OUT18/14196

**Vickery Extension (SSD 7480) – Modification
EIS Exhibition**

Alison Collaros
A/Manager, Assessment Advice
Lands and Water - Strategy and Policy
26 October 2018

RAIL SPUR INVESTIGATION CORRIDORS

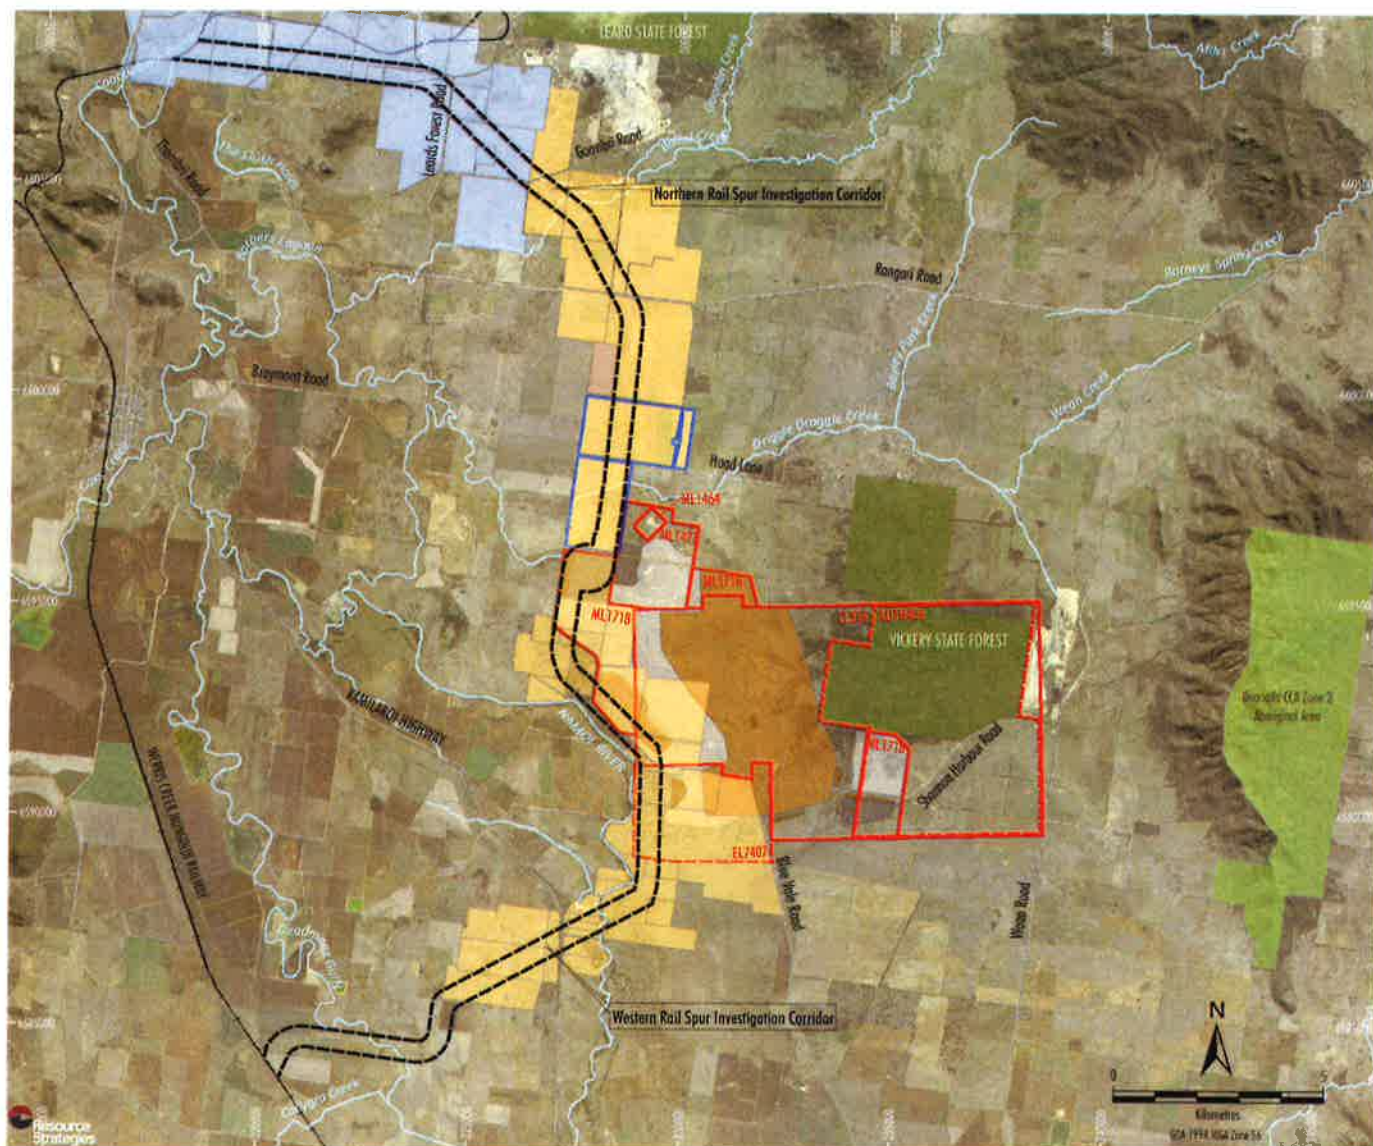
- The EIS should assess the risk of the actively eroding river bend on the Namoi River to the long term stability of the rail infrastructure and potential impacts to the geomorphic stability and hydraulic characteristics of the river itself. This is to confirm whether location or design change is required and to inform future mitigation requirements.
- Development must not be undertaken on affected Crown reserves or Crown roads prior to purchase or other written authorisation of impact by the Department. This includes Reserves currently held under Licence 488324 to Coalworks (Vickery South) P/L for the purpose of Investigation.

- The rail spur near the Namoi River is in close proximity to an actively eroding river bend. This represents a risk into the future of potential undermining of infrastructure that needs to be considered and planned for.
